**WEST SUSSEX COUNTY COUNCIL
PLANNING SERVICES CONSULTATION**

SUBJECT: Y/5/17/OUT

Outline application for 51no. dwellings with all matters reserved except for access. This application is a Departure from the Development Plan.

Cinders Nursery & Land R/O, Cinders Lane, Yapton, West Sussex, BN18 0JJ

SITE ACCESS ROAD VISIBILITY SPLAY (SCALE 1:200)

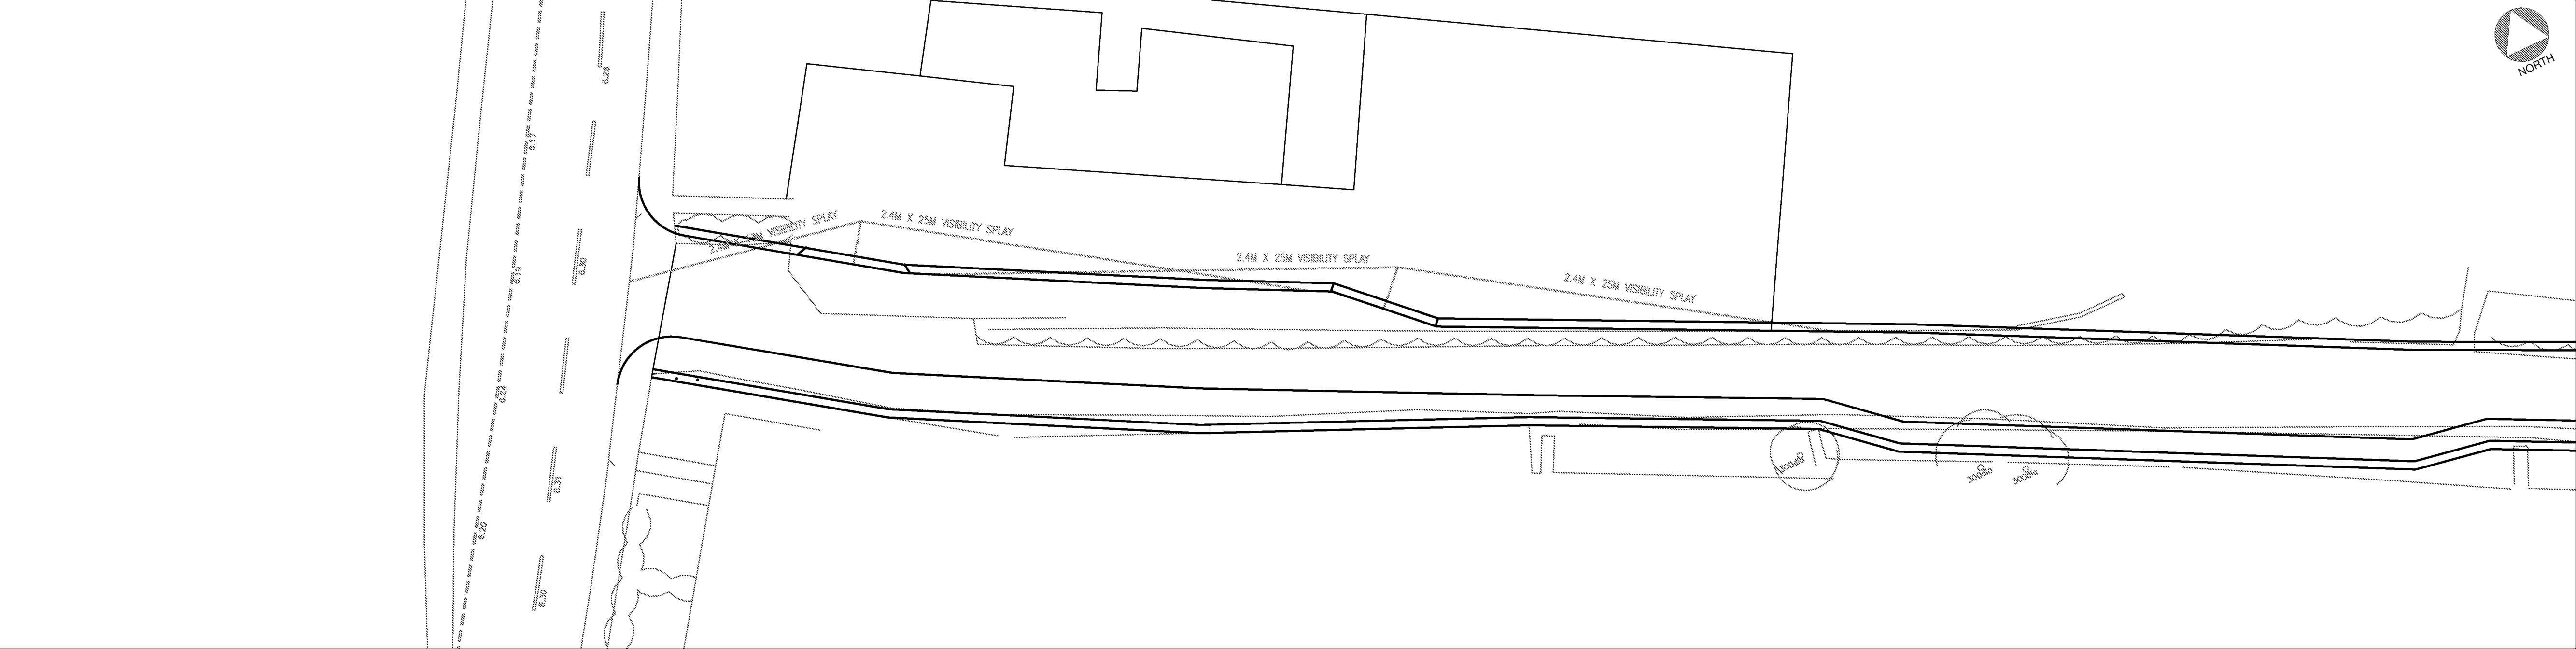
One problem has been raised by the Auditor relating to the presence of parked vehicles in the visibility splay. As established in Manual for Streets 2 (10.7.1), parking in visibility splays is common and does not appear to create significant problems in practice. The Designer has accepted the problem identified by the Auditor and, whilst the Designers Response indicates that the recommended remedial measure is not accepted, proposes to use all reasonable endeavours to promote a Traffic Regulation Order (TRO) restricting parking in the vicinity of the access. The Applicant will be required to fund the promotion and advertisement of the TRO and this should be secured via Section 106 Agreement – the current cost is £7,000.

No development shall be commenced until such time as a Traffic Regulation Order or revision to an existing order, promoting the provision of no waiting restrictions adjacent to the access has been submitted to, and subsequently promoted by, the Local Highway Authority.
